CLOVERLEAF FILING NO. 2

A REPLAT OF A PORTION OF TRACT B, WOODMOOR PLACER
 LOCATED IN THE NE1/4 OF SECTION 23 AND THE NW1/4 OF SECTION 24, TOWNSHIP 11 SOUTH, RANGE 67 WEST OF THE 6TH P.M.
 COUNTY OF EL PASO, STATE OF COLORADO

JOB NO. 25158.01
 MAY 7, 2021
 SHEET 2 OF 7

JOB NO. 25158.01
MAY 7, 2021
SHEET 6 OF 7

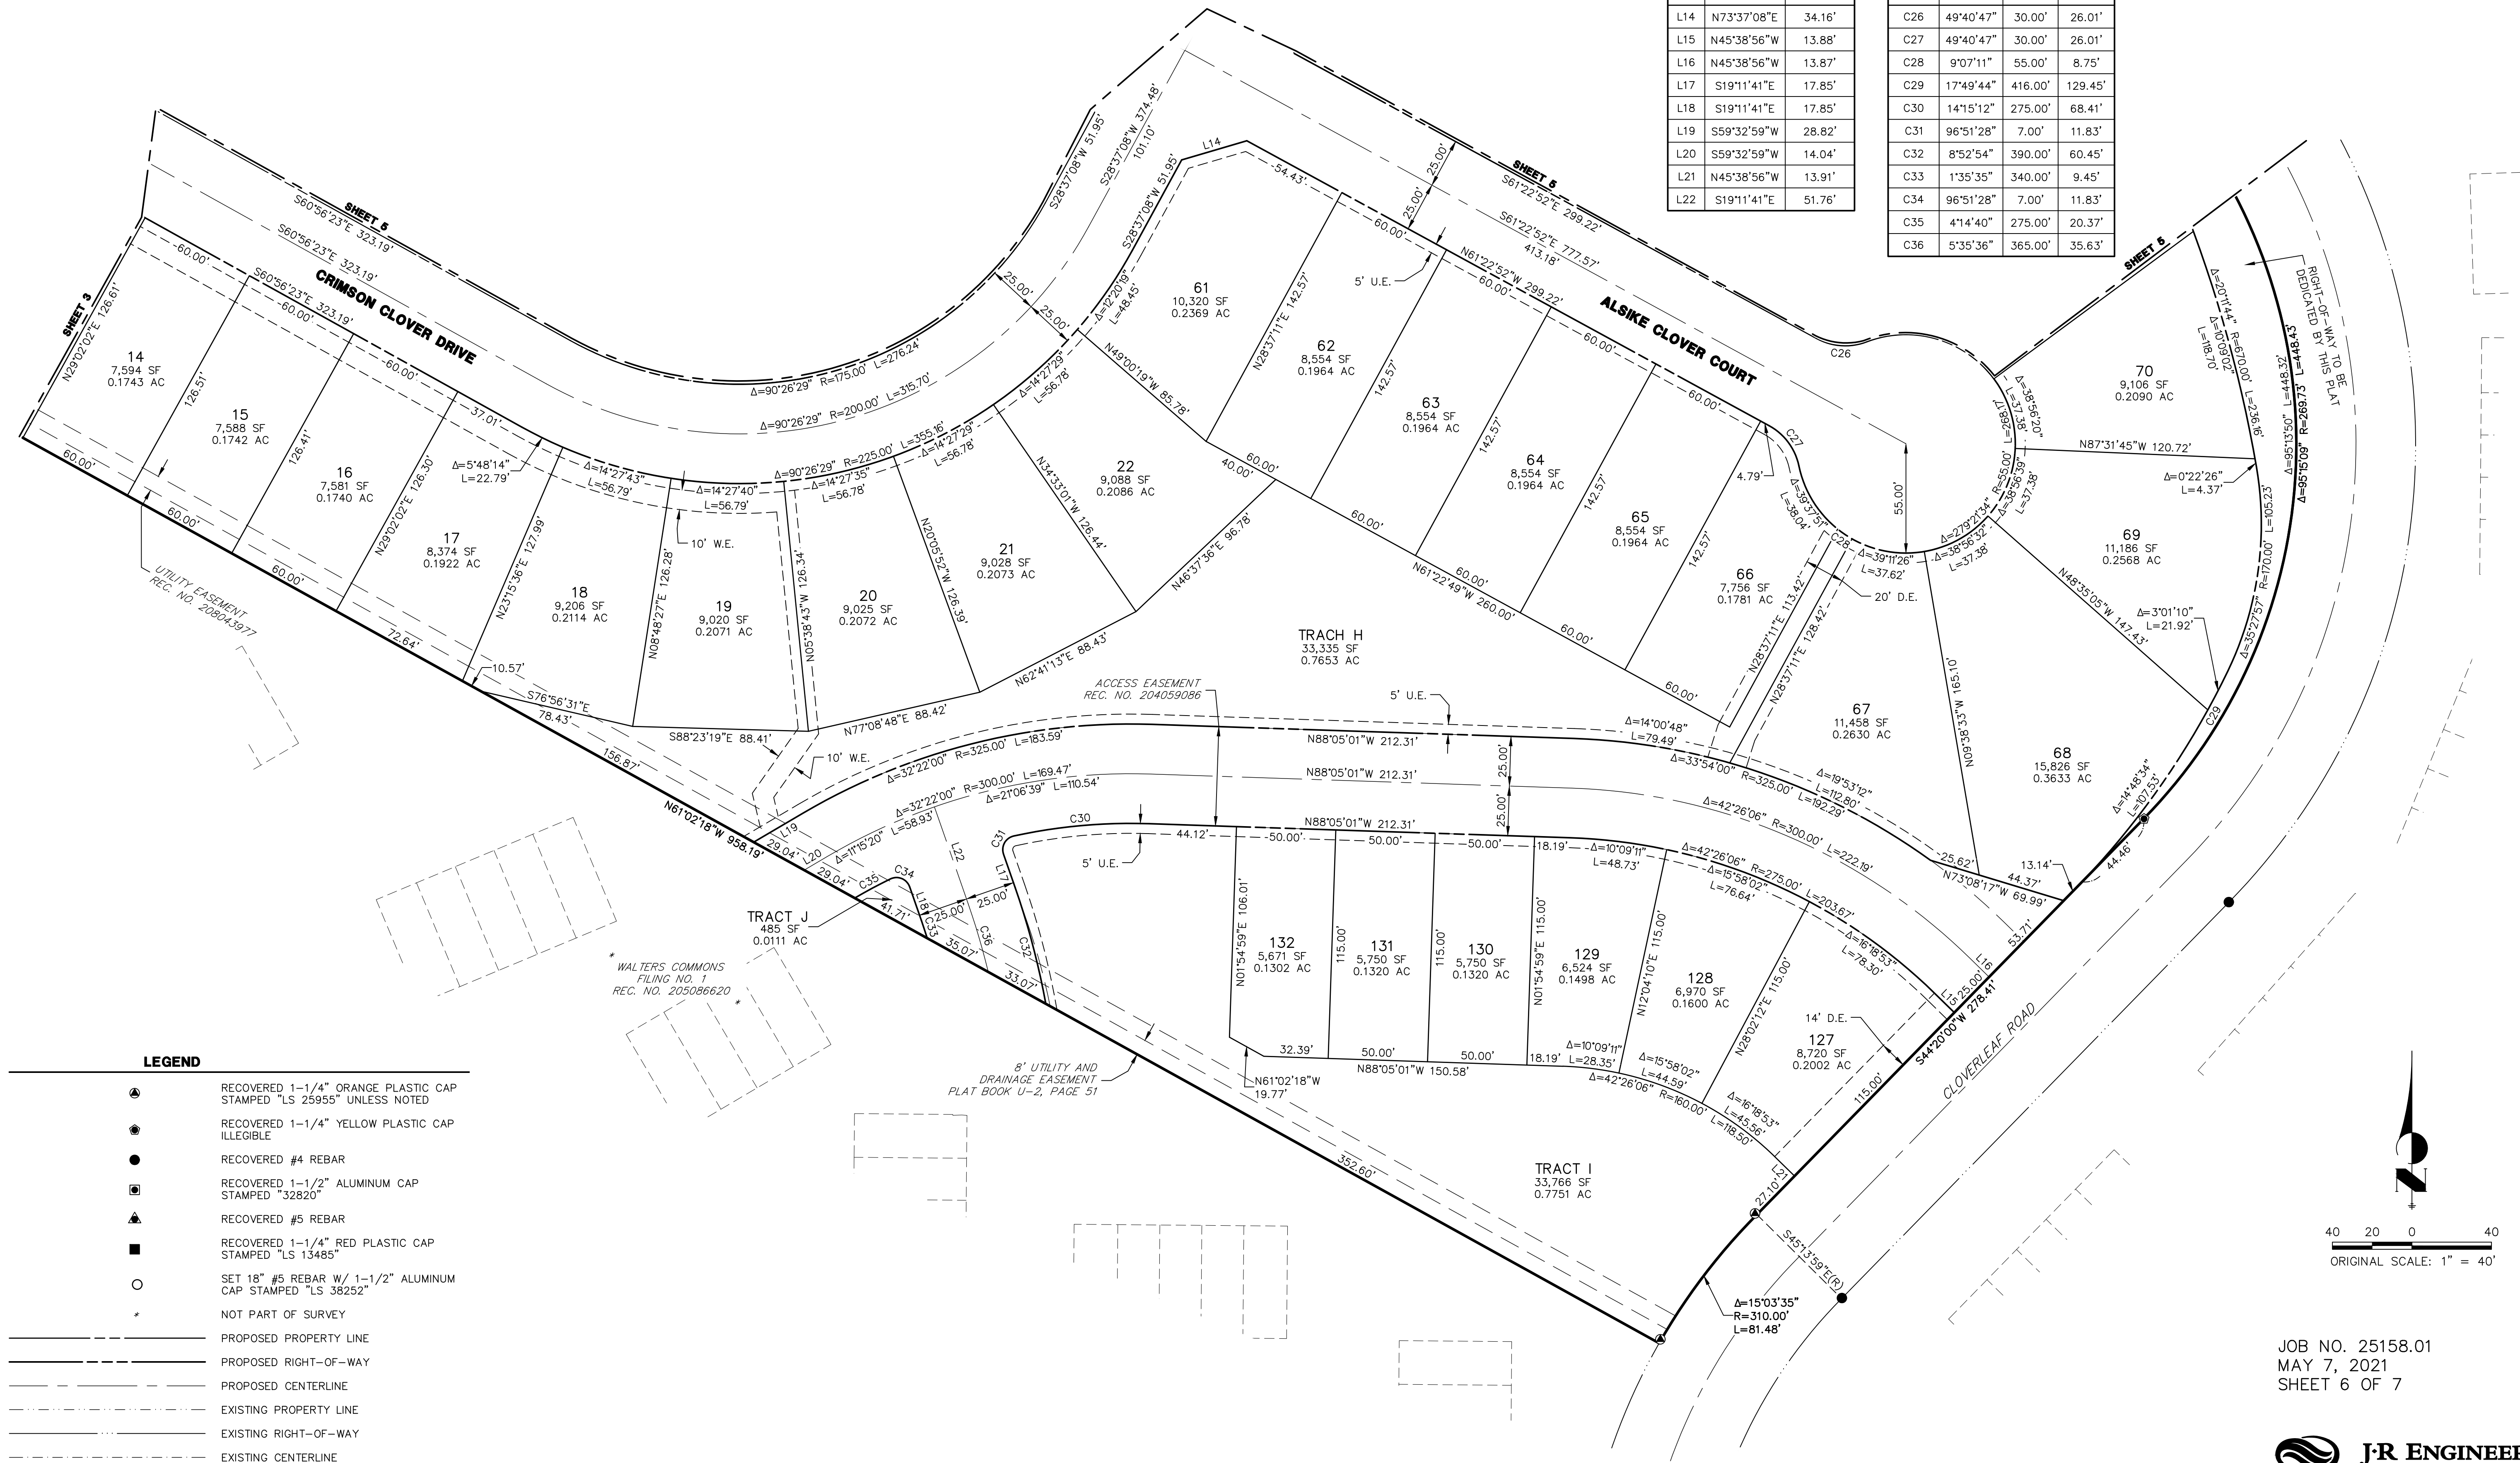
Change the matchline linetype so it's not confused with the road centerline. typical on all sheets

A retaining wall is constructed within lots 67, 68, 127-132. Add a plat note specifying who will own and maintain the retaining wall. If the district then include an easement.

Add the sight distance easement shown on the preliminary plan

what is this line?

Walters Point is now included. Revise tract J to be consistent with the preliminary plan which included Walters Point

Changed

Added to Legend. Add all abbreviations to the legend or revise the callouts.

JOB NO. 25158.01
MAY 7, 2021
SHEET 7 OF 7

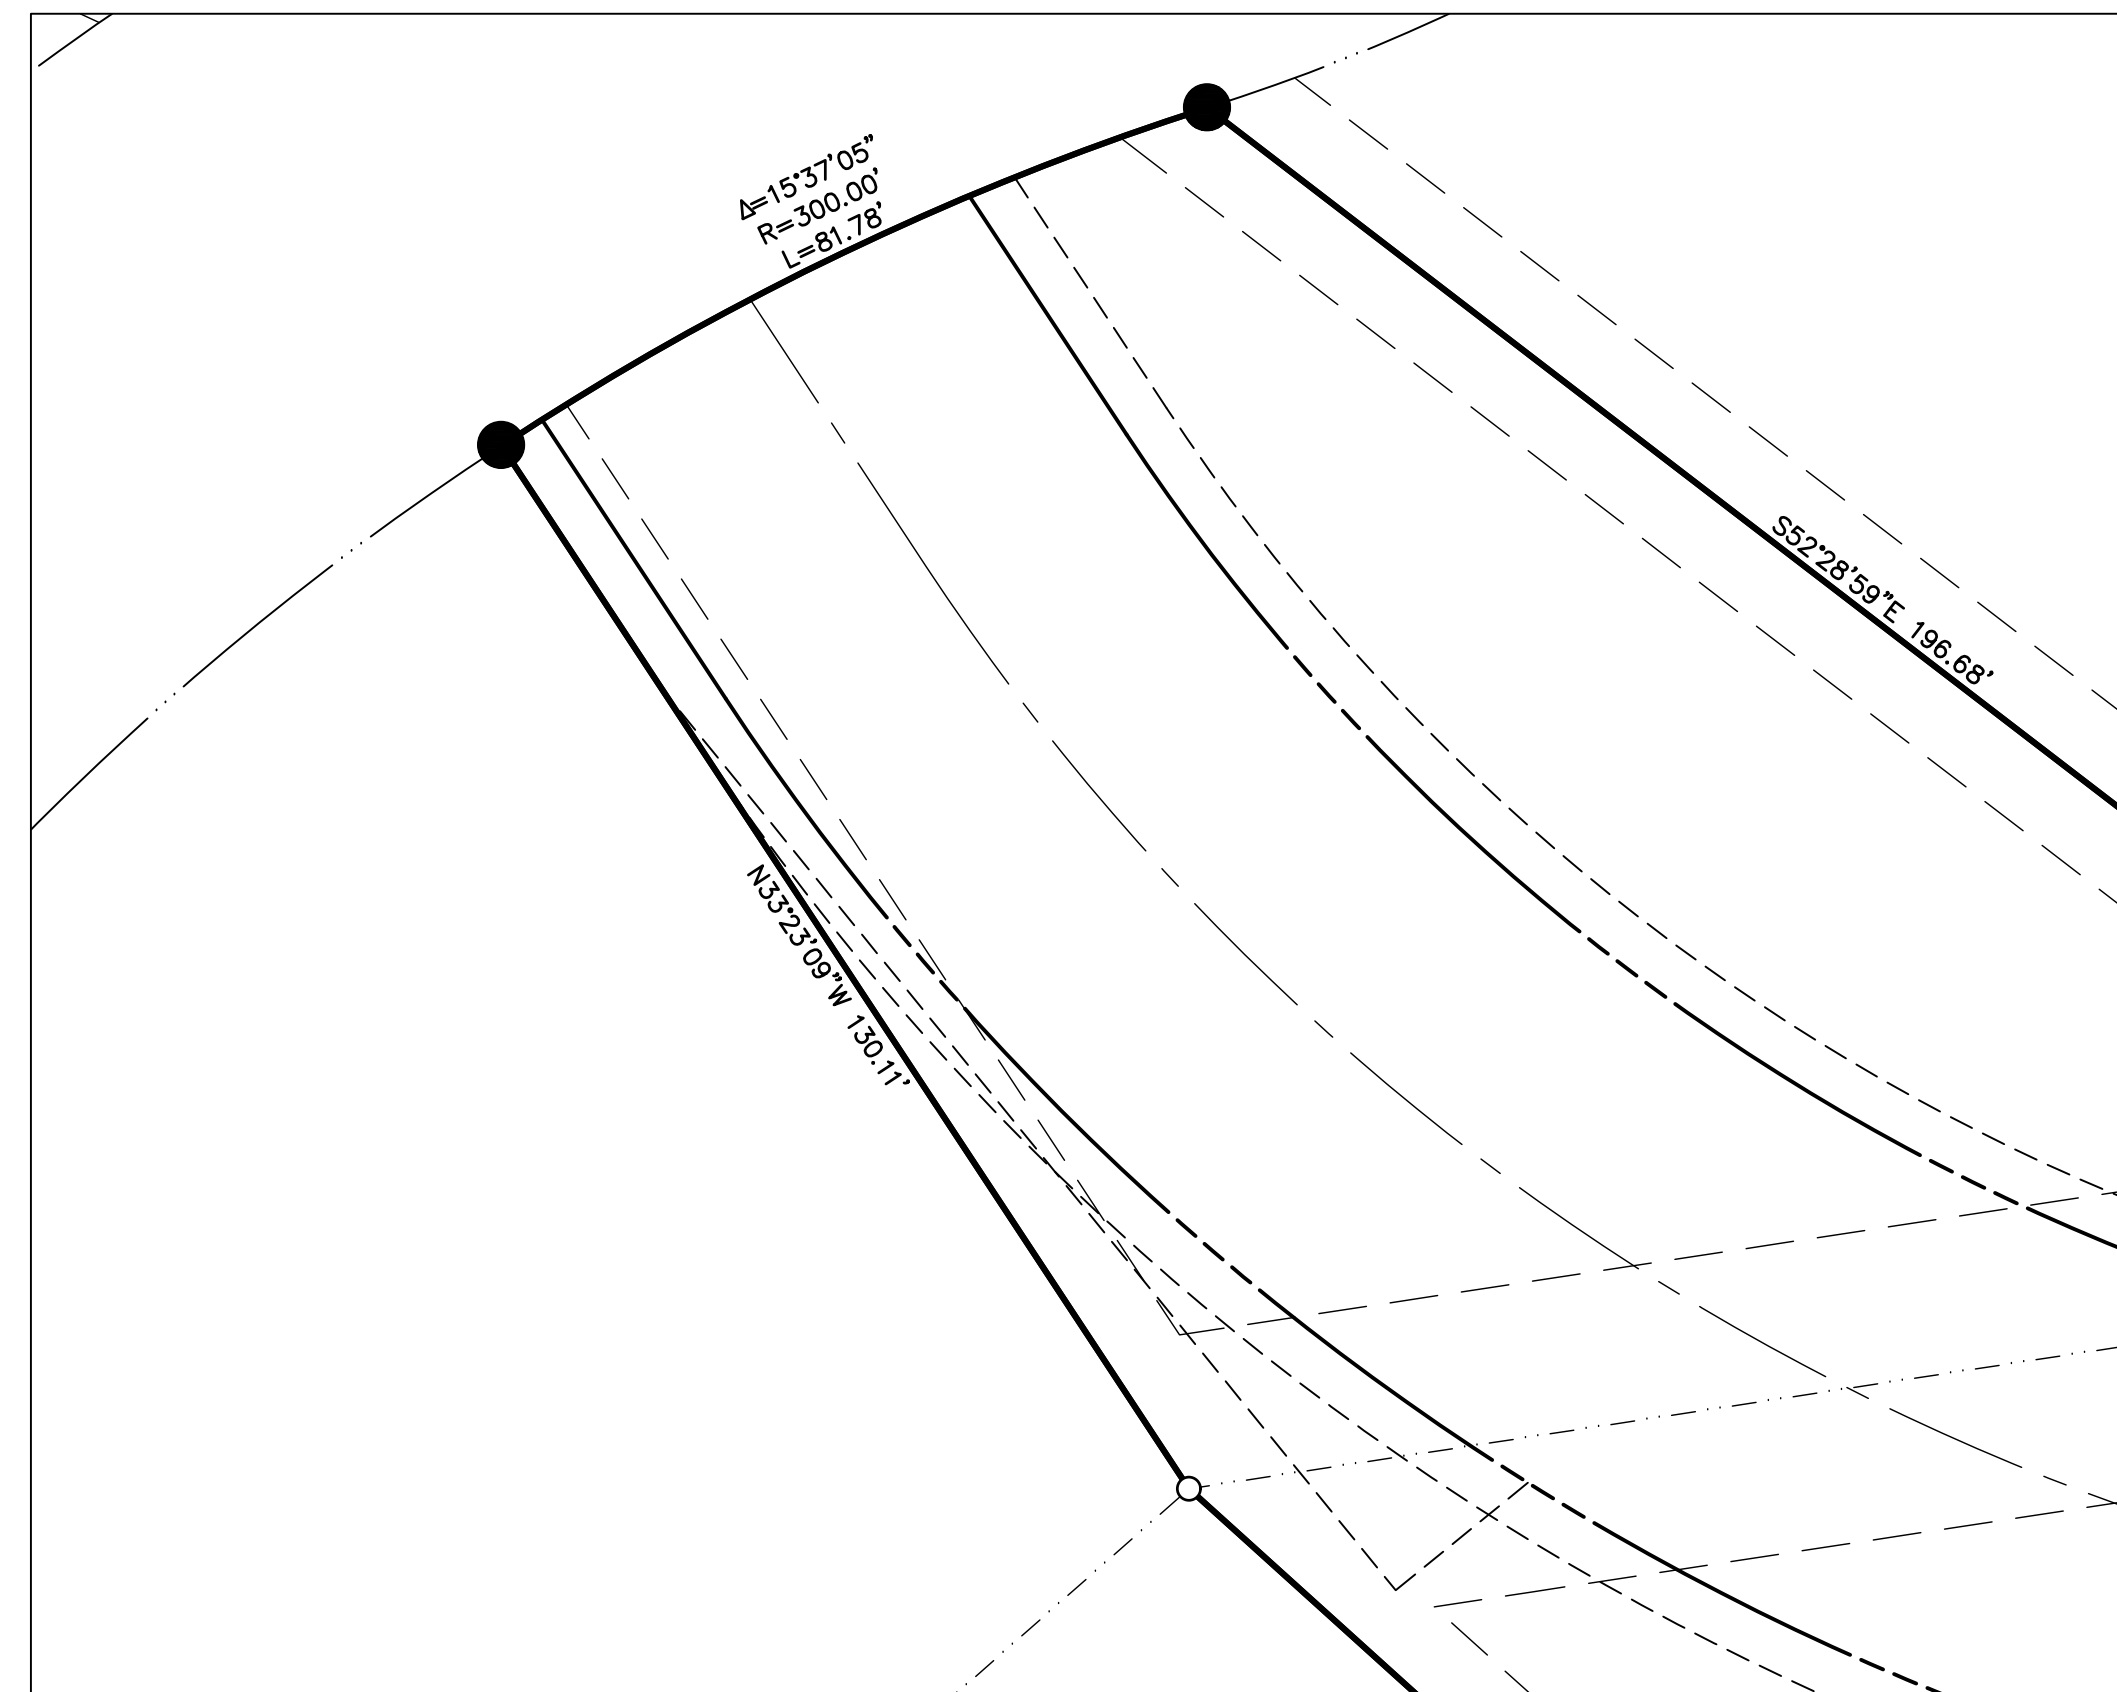
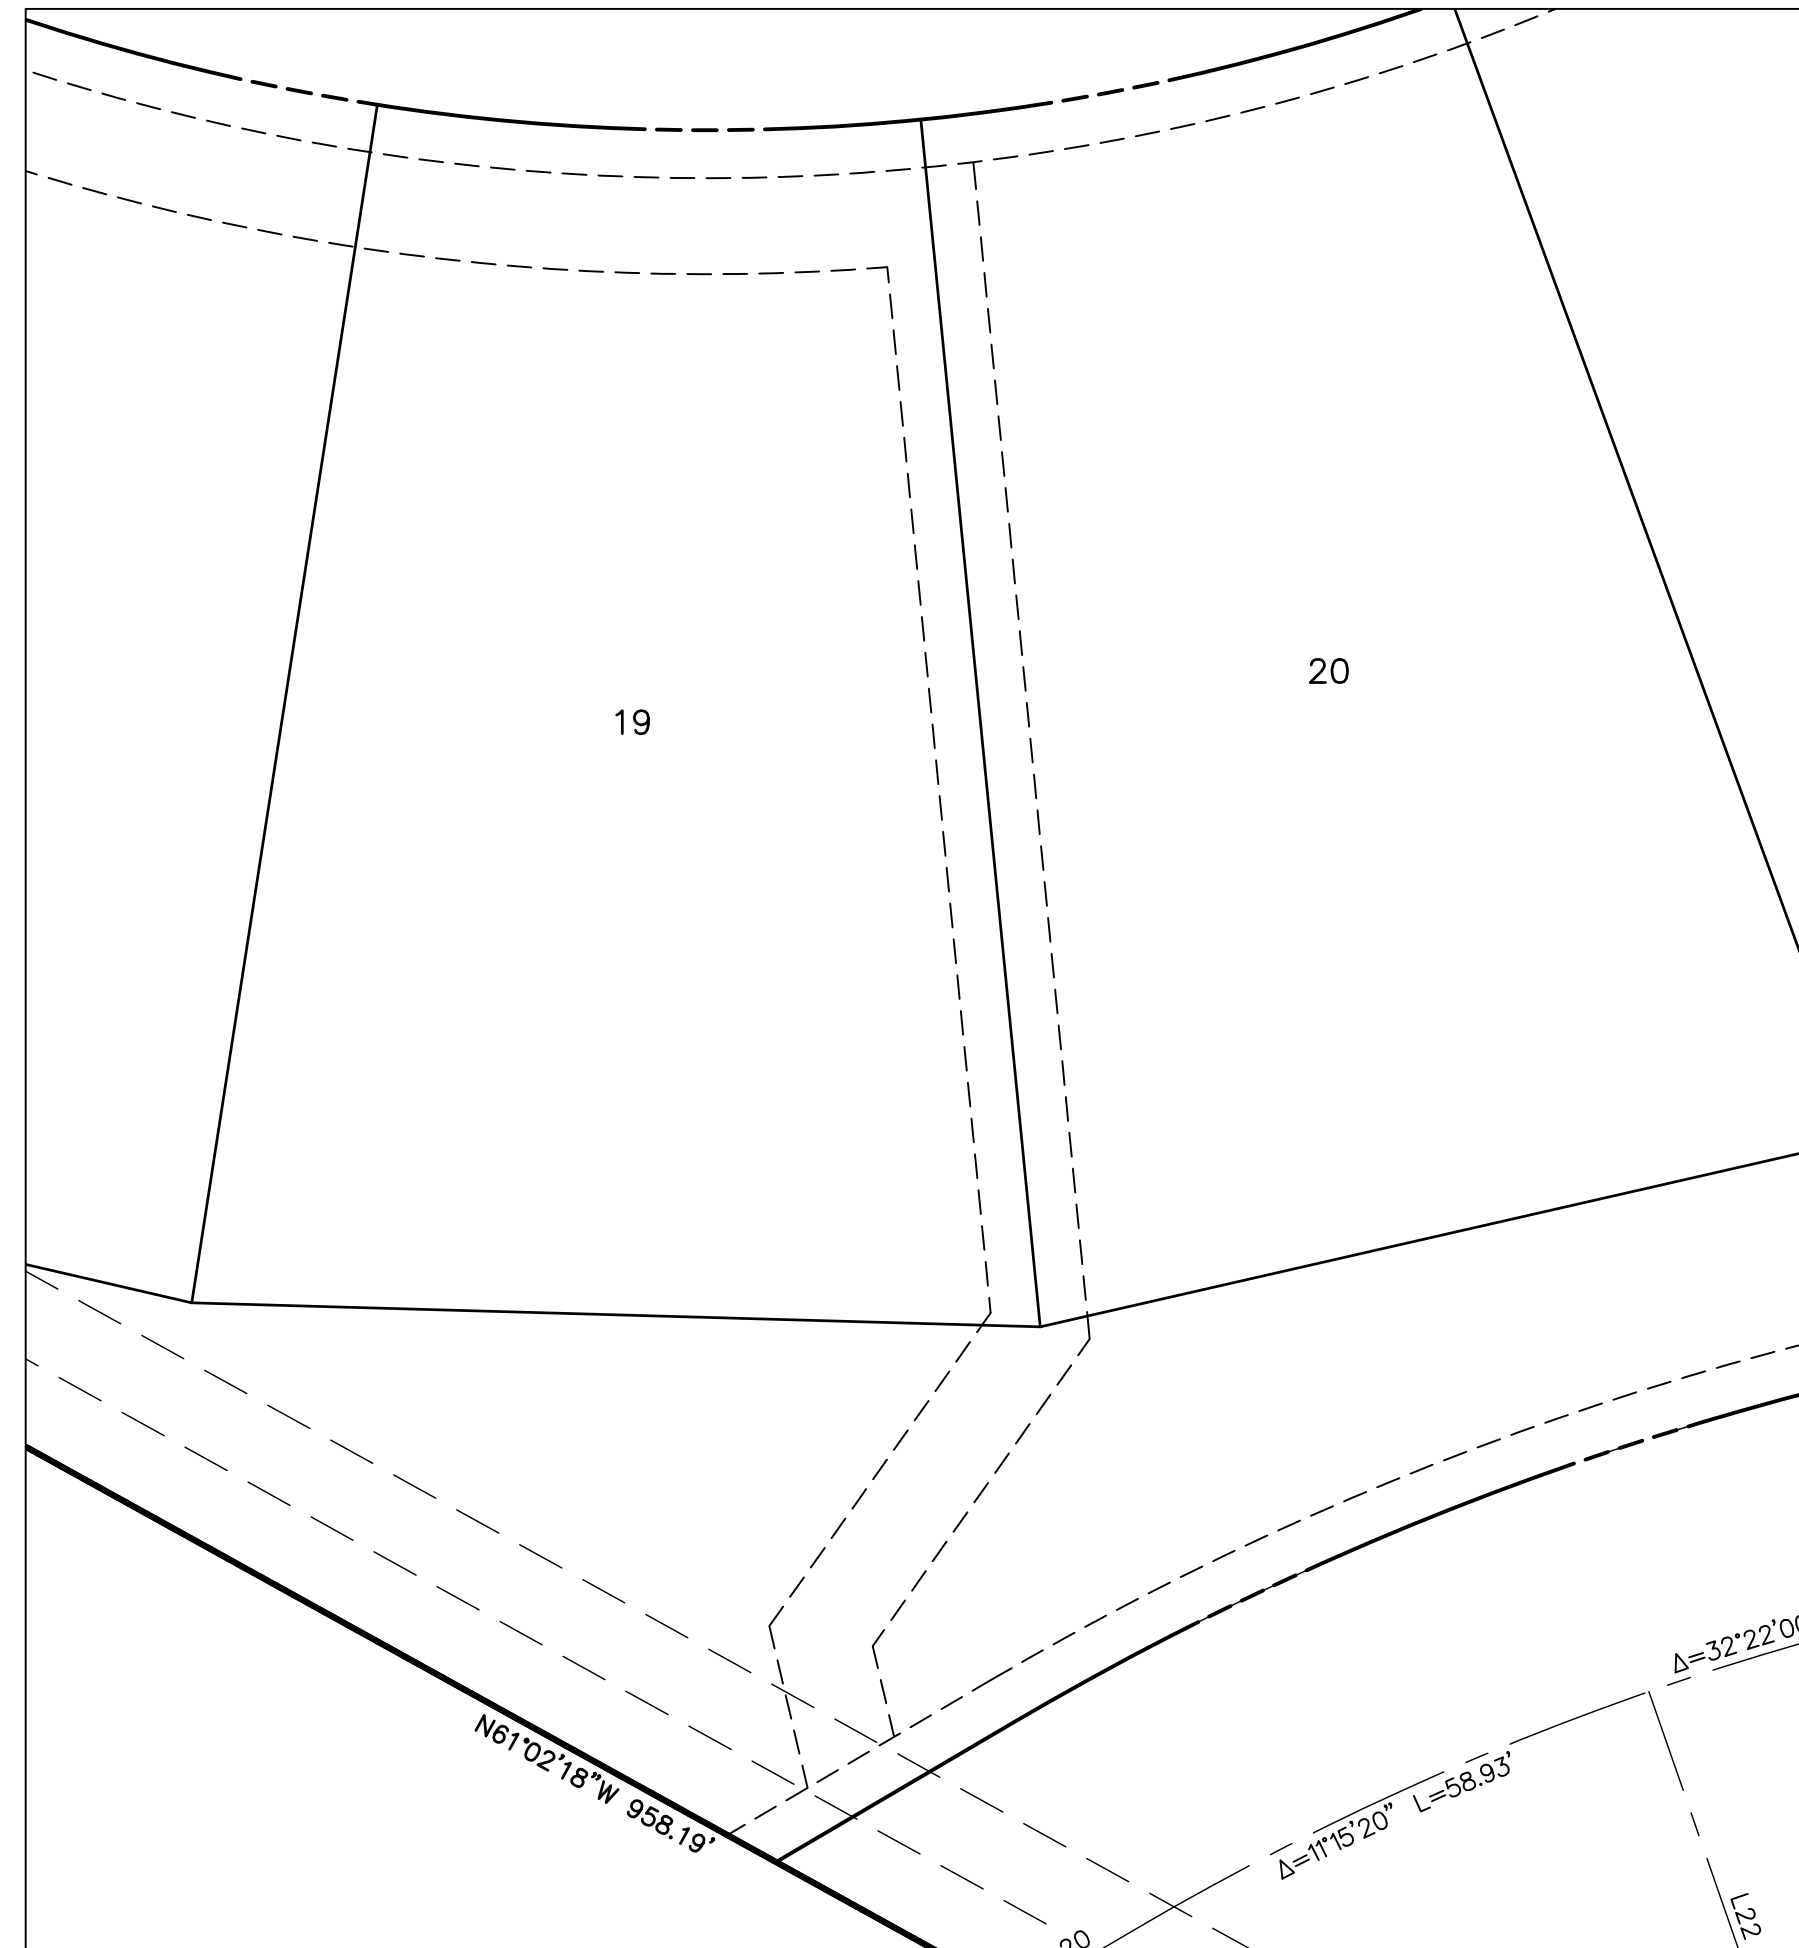
Not sure what the specific information this page is trying to convey.
If it's the easements then provide the bearing/distance information
for the easements
Will be reviewed on the resubmittal

Increase text size
it's legible

Detailing easements Bearing Distances added
